Amended Concept Development Application (SSD-9579) for an Over Station Development (OSD) above the new Crows Nest Metro Station including maximum building envelopes, gross floor area, conceptual land uses, car spaces and signage zones.

Submission by Wollstonecraft Precinct Committee (Preliminary)

**2 WEST ELEVATION - PACIFIC HIGHWAY**  
1 : 1500

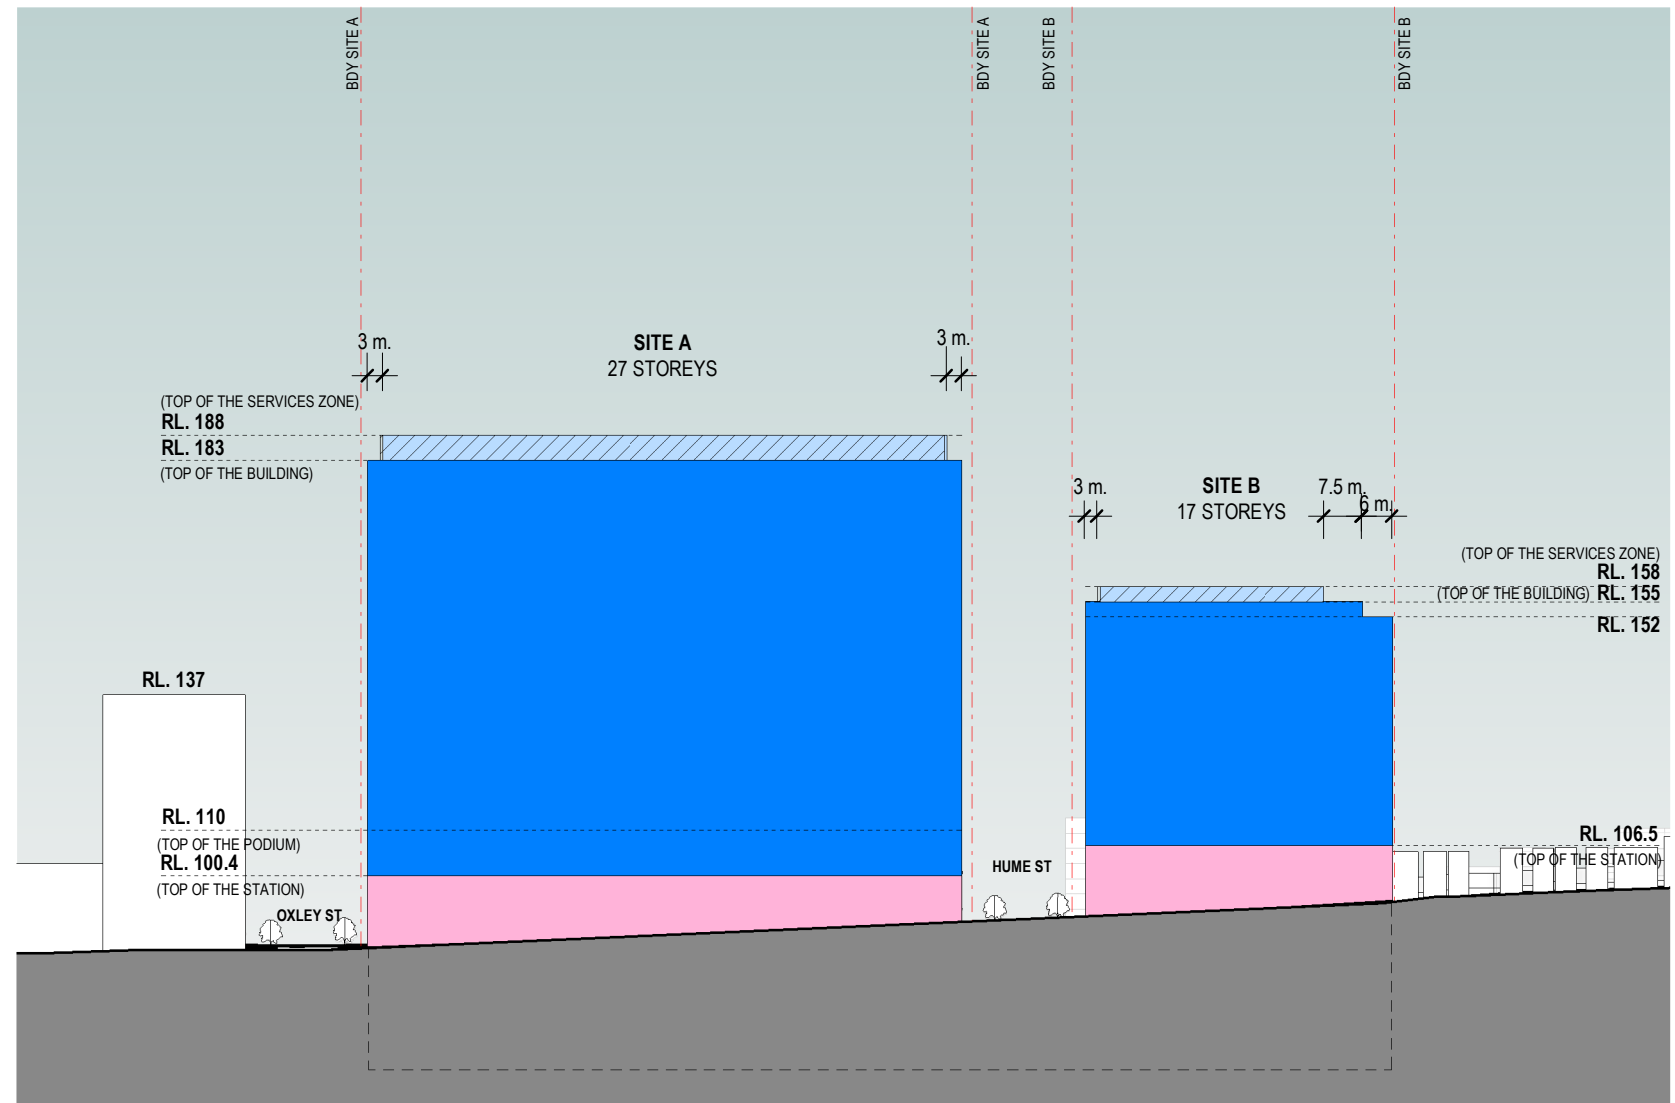
The two images are shown at different scales which gives a misleading impression that the amended project is very much smaller than originally exhibited. Yet, the only material change to the envelope is a height reduction of 7.6 metres to Building A and a truncation of the south face, offset by elimination of the large vertical gap between the two towers as originally exhibited. According to Sydney Metro this envelope is 20% less than the original proposal. However, it is one building, not two and will be a very imposing frontage over the full block. In reality its bulk is reduced by 6% not 20%.

It is acknowledged that the new commercial office building on Site 'A' has a changed envelope, but the 20% reduction is misleading. The envelope ignores the fact there were originally two towers proposed on this block with a large gap between.

Taking into account the net area of the western faces, the commercial office building even with the steppes towards the south, is only 6% less than that of the twin towers. Hence its bulk and scale will be a blot on the landscape and will forever block out sky views as well as reducing solar access. It will be entirely out of context with the low rise suburb of East Wollstonecraft and the Crows Nest village.

It is the OSD specifically on Site A and Site B that are contrary to the village atmosphere. Increased bulk and scale with heights to RL180 and RL155 can never be described as being in context with the village. They are just too high and bulky, looking like a box plonked atop the otherwise attractive new entrance to the village. Site C office building above the station eastern entrance makes no sense at all.

2.1 General Arrangement Plans - Site A

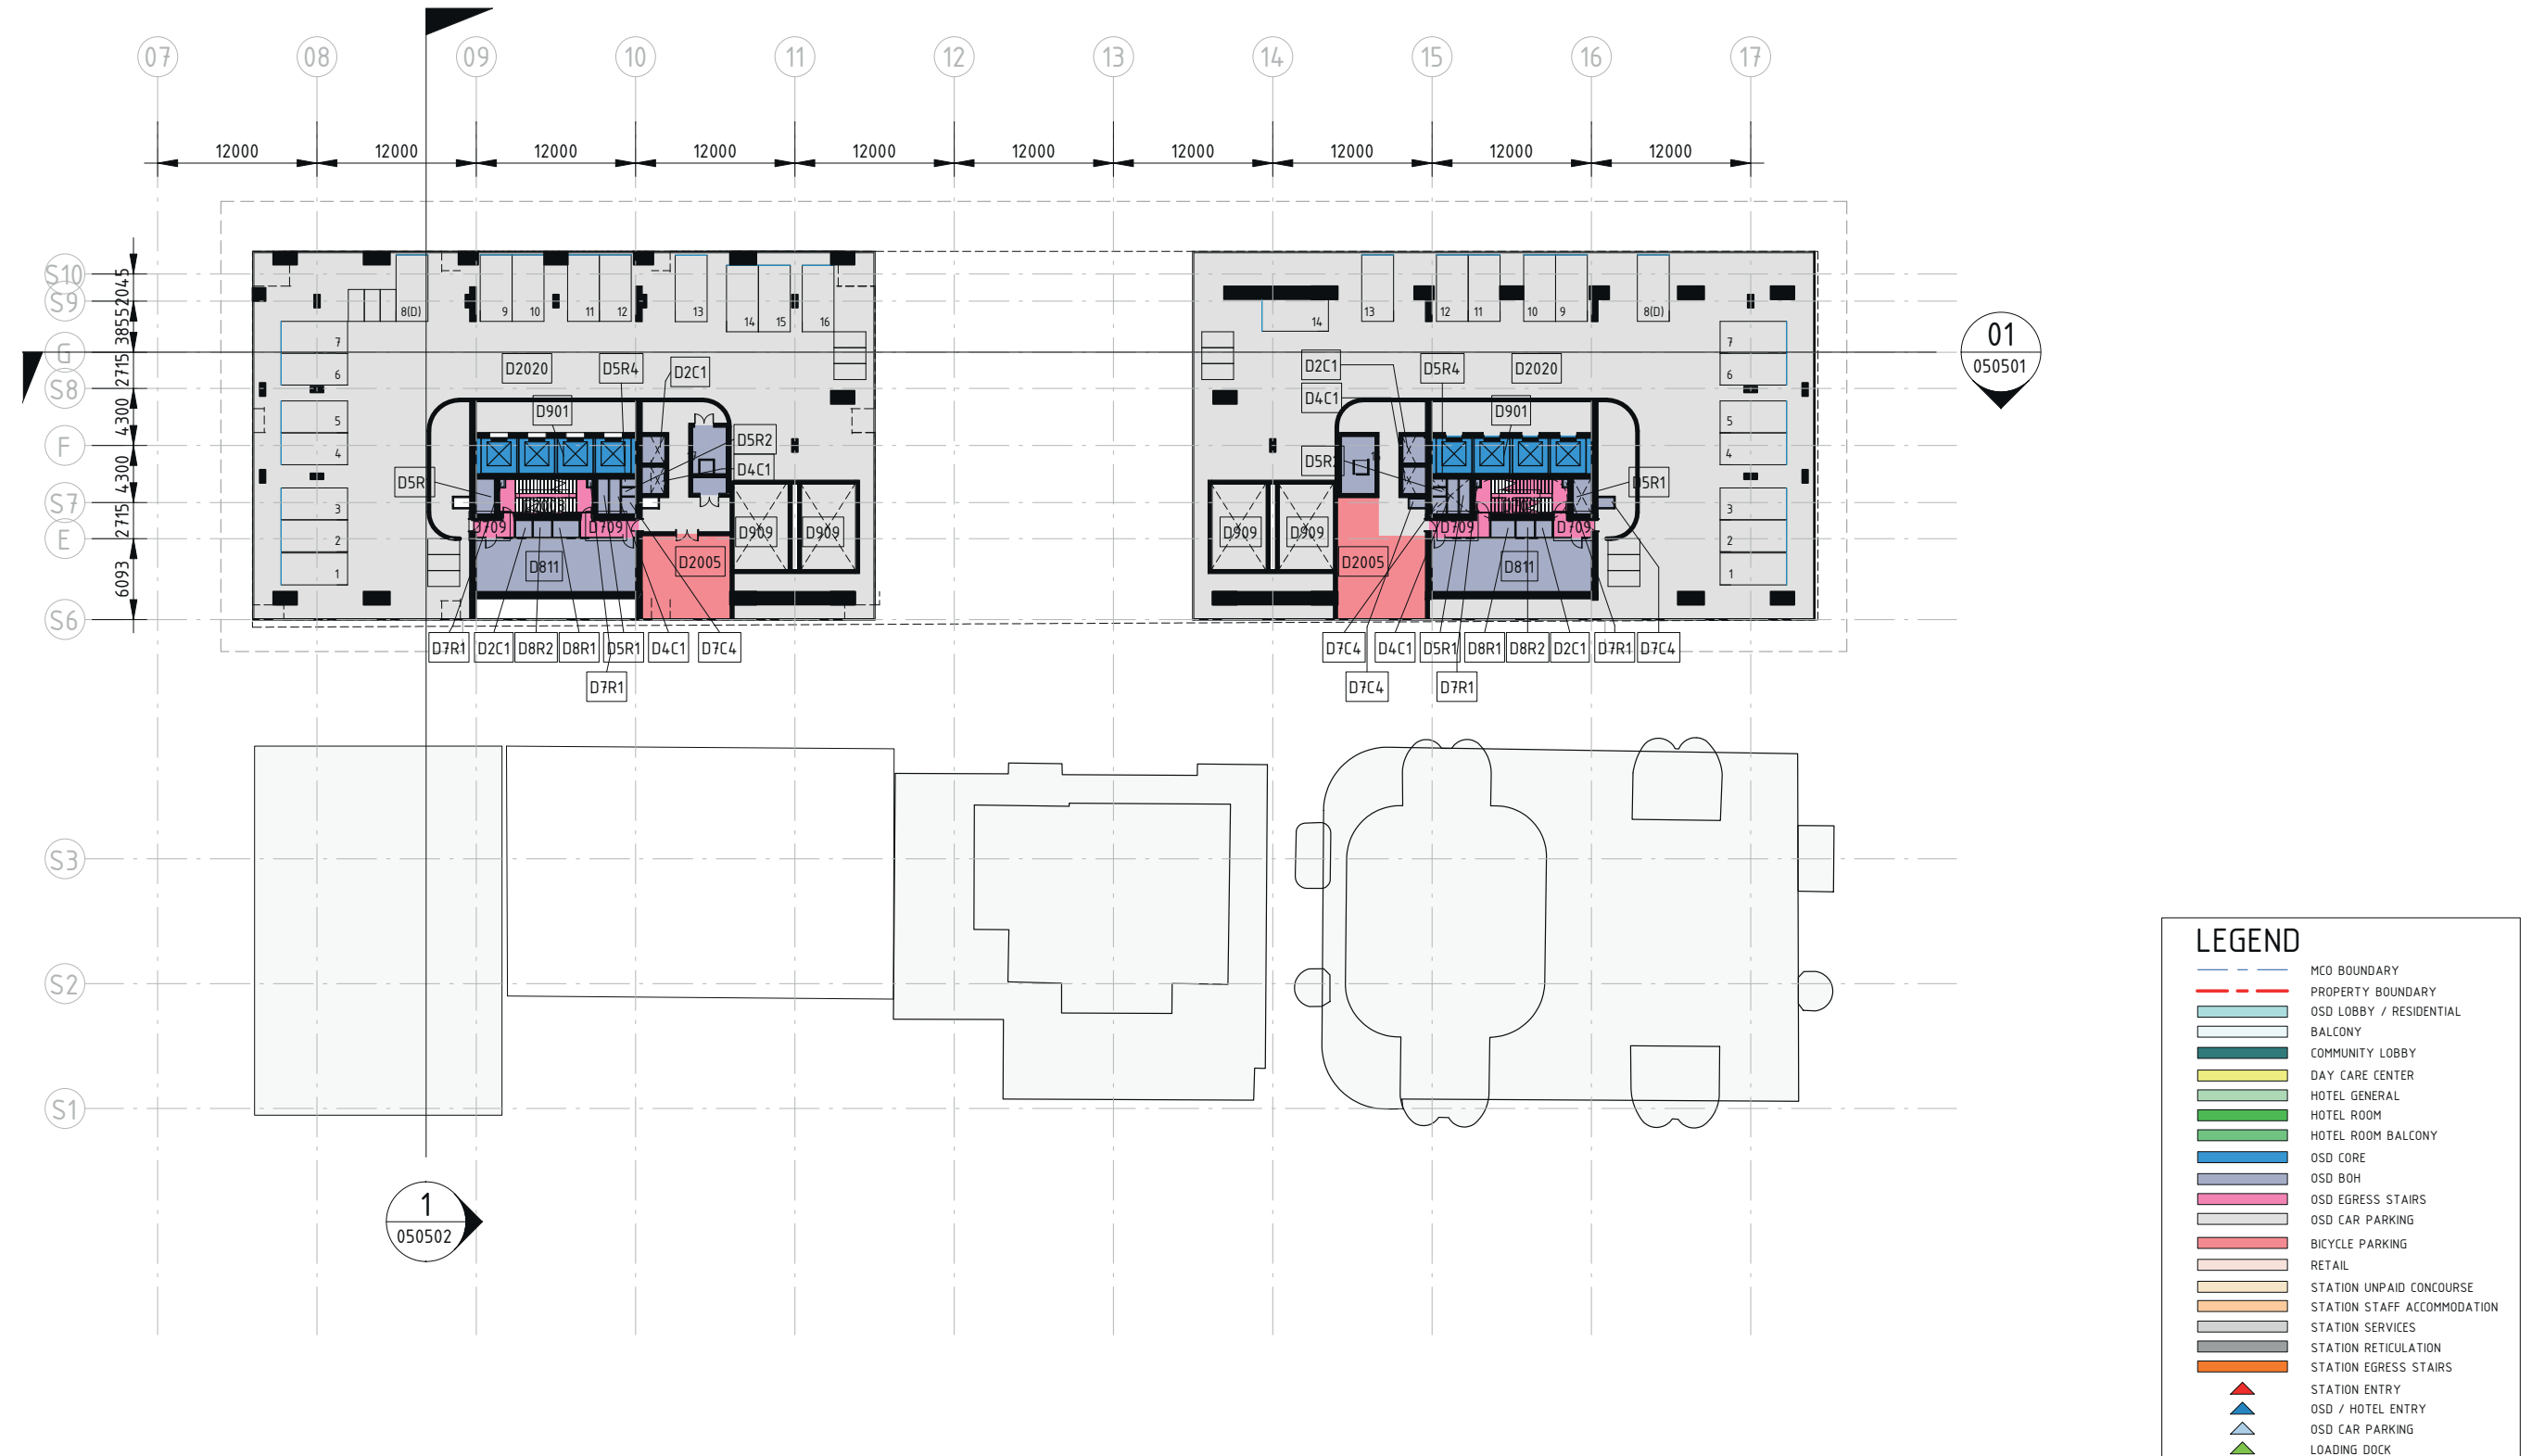
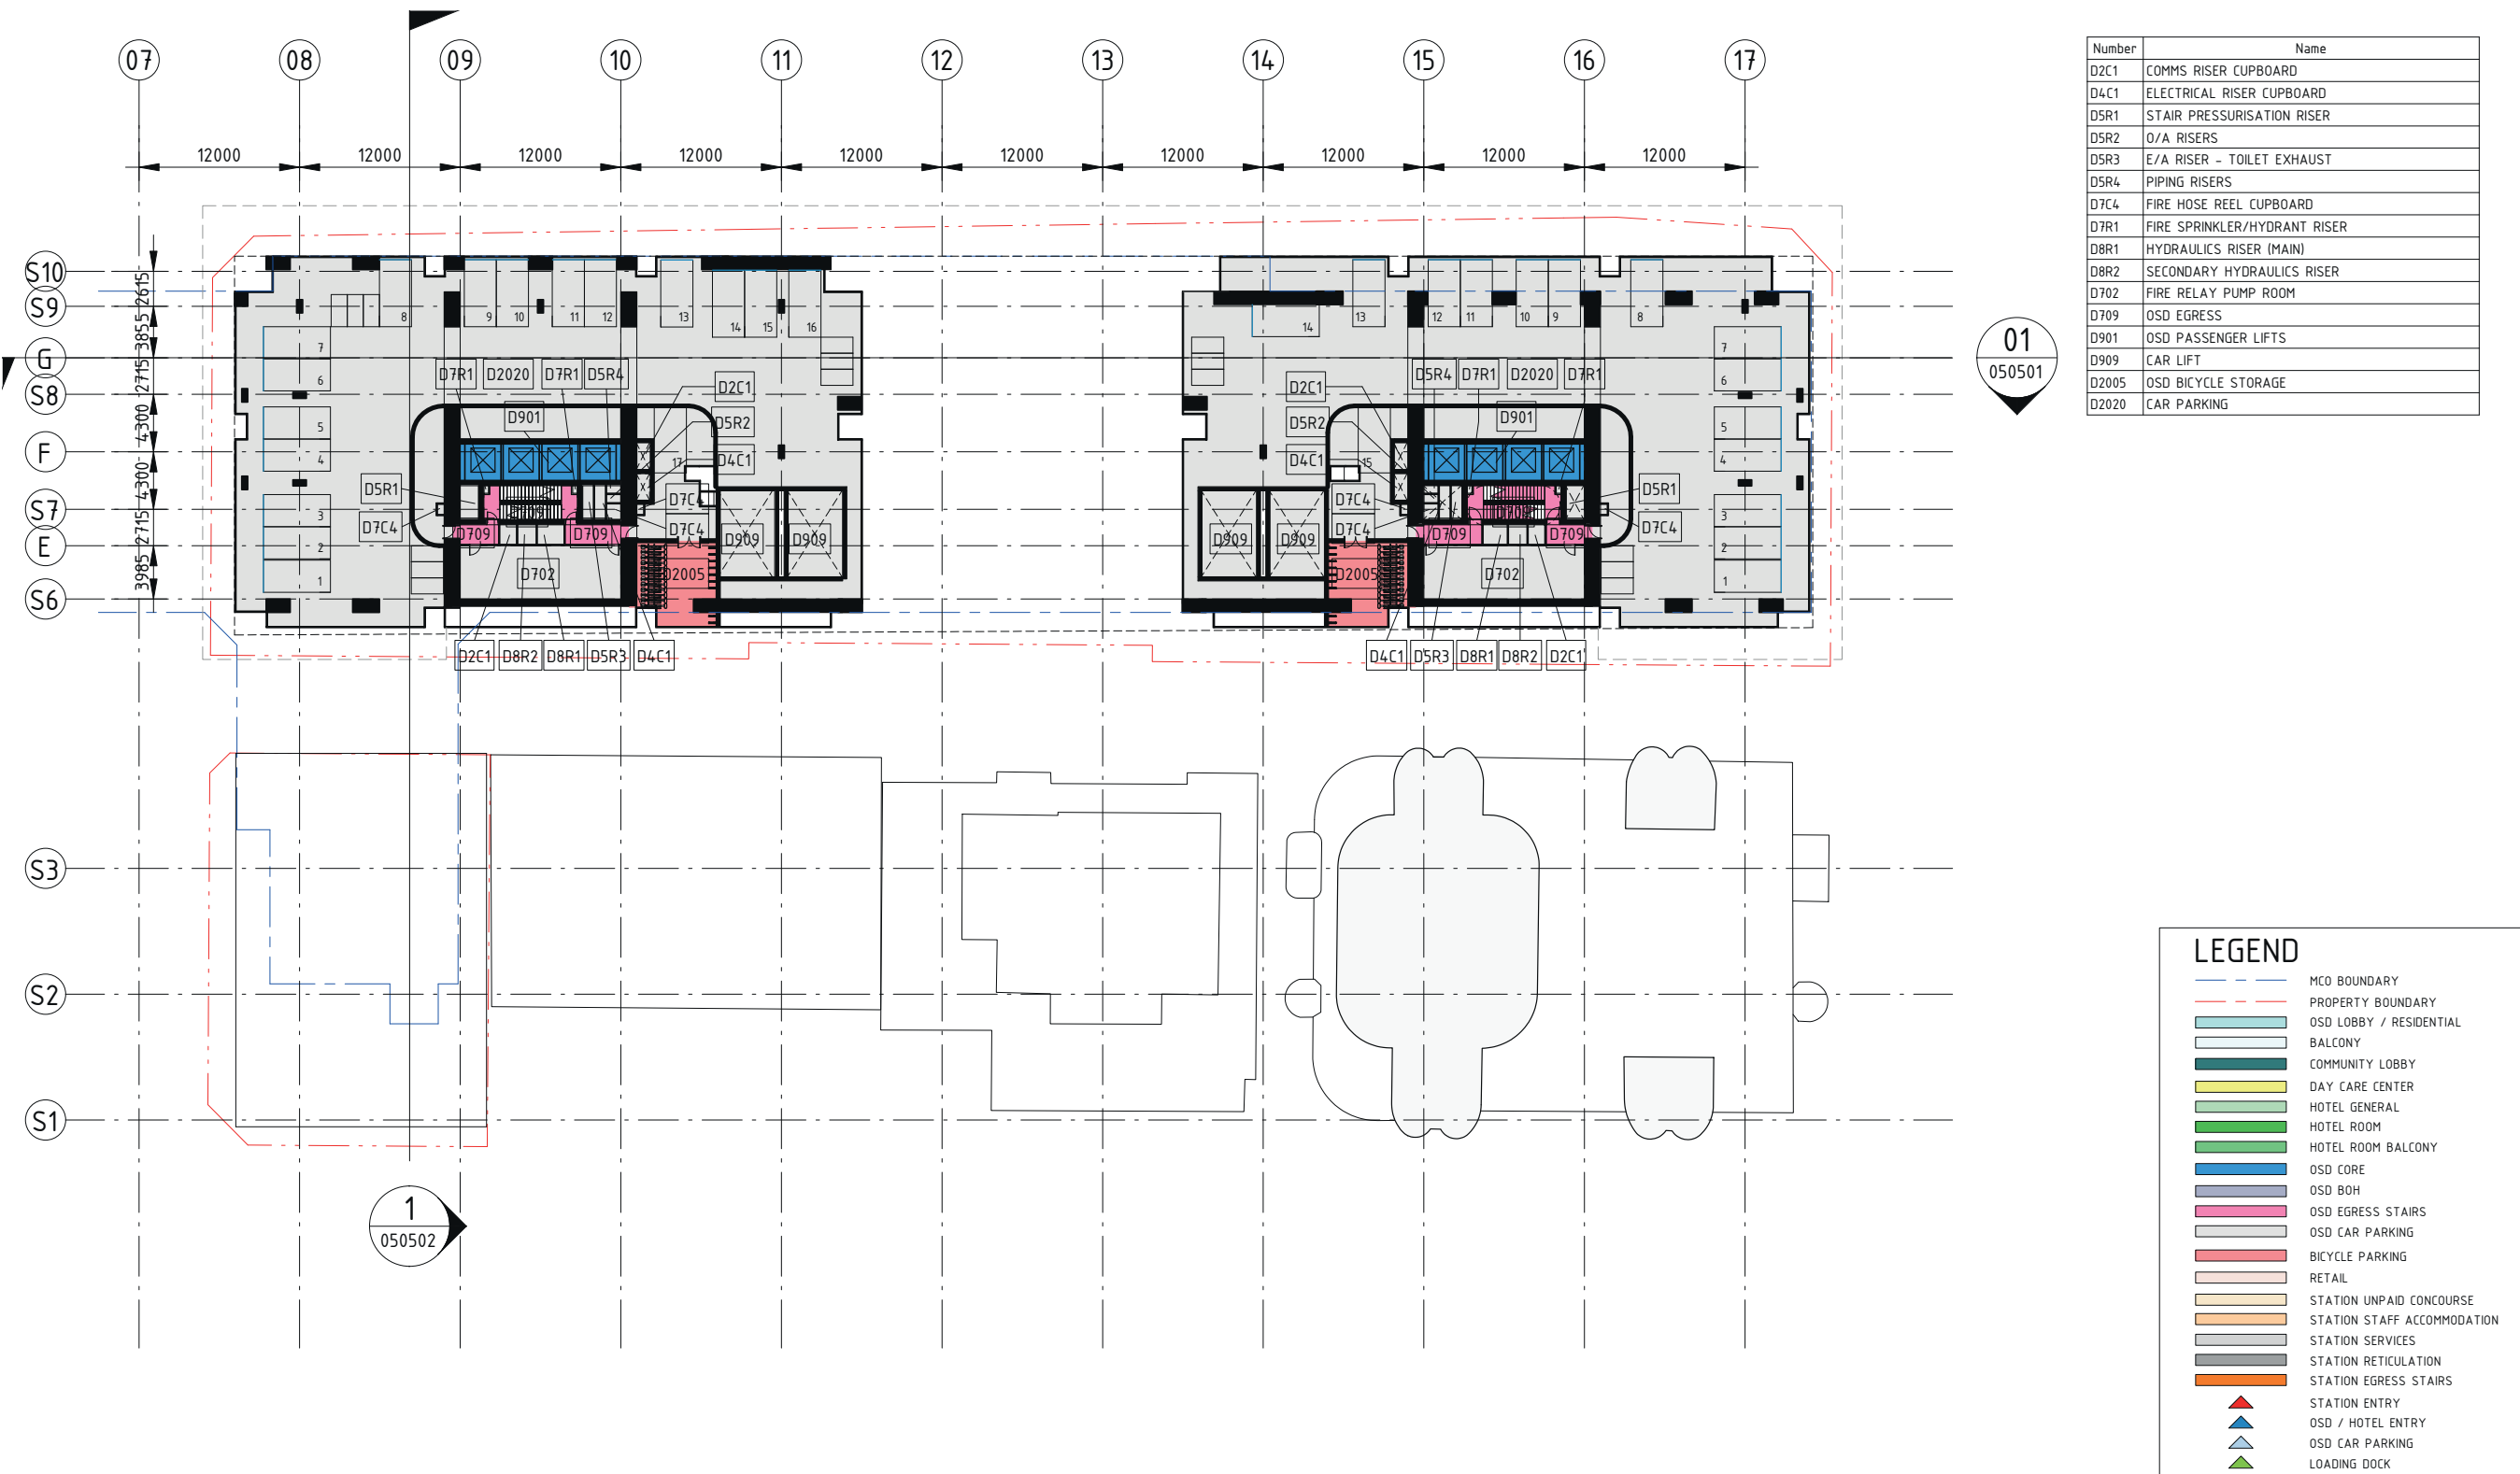
The response from Sydney Metro results in overdevelopment of Site A.

Conclusion: The amount of office space being provided by Sydney Metro is about twice as much as needed for Crows Nest and therefore Building A should be drastically reduced in height leading to less floor space. This would help reduce the over shadowing of the Crows Nest Village which has been ignored in the extensive analysis that has narrowed consideration to only over shadowing on Willoughby road, Ernest Place and Hume St Park. The solution of Sydney Metro to build a massive amount of office space is dated and pre-Covid. Commercial office space demand is and will remain depressed for decades. A better solution would be to both reduce height and also have the government fund job creation initiatives - a recommendation of its own consultants in the draft SLCN 2036 plan.
